CITY OF ALBUQUERQUE

July 22, 2022

Re: International School at Mesa del Sol
2000 Eastman Crossing SE
30-Day Temporary Certificate of Occupancy
Transportation Development Final Inspection
Engineer's Stamp dated 1-18-21 (R16-D099)
Certification dated 11-07-22

C-100

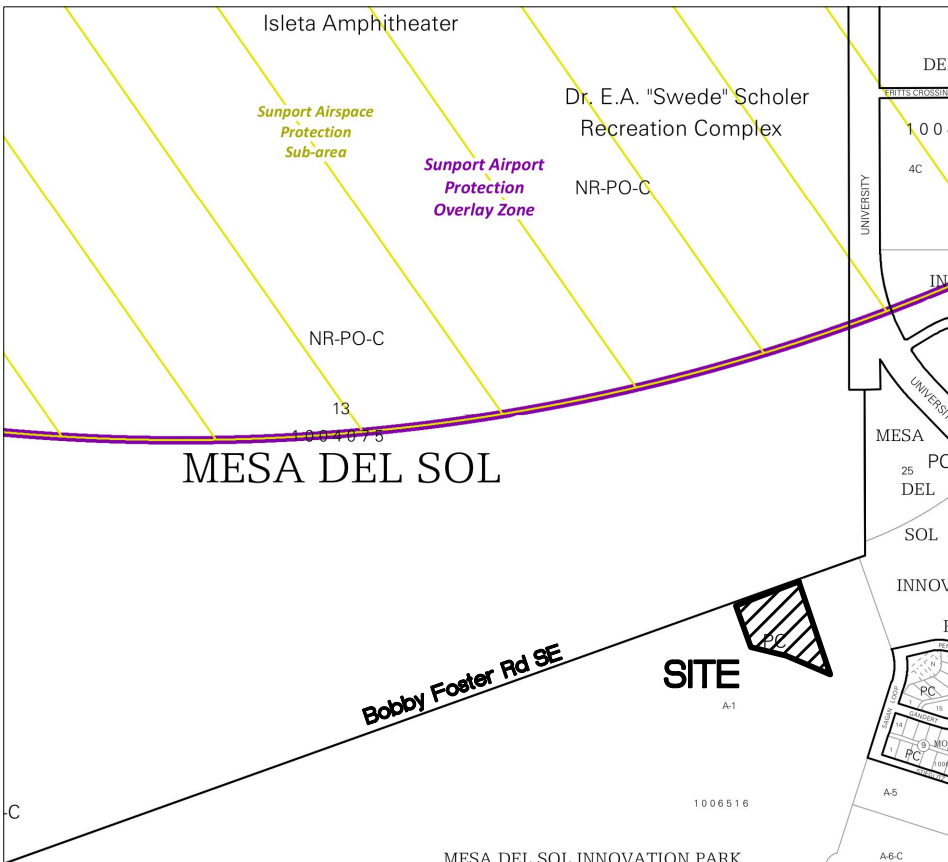
- Per site visit the width for the ADA parking space was 8 ft. Please provide the min. required width which should be 8.5 ft. Also, note that the width for the ADA parking space at the west side was 8.5 ft. (correct the width for the other three ADA parking spaces).
- Tripping Hazard: the sidewalk and the landscape at the north side of the site needs to be at the same level. Please see attached pictures.
- Per site visit the width for the regular parking spaces was 8.5 ft. please red mark the site plan, and change the width from 9 ft to 8.5 ft.

Once these corrections are complete, email pictures to malnajira@cabq.gov for release of Final CO.
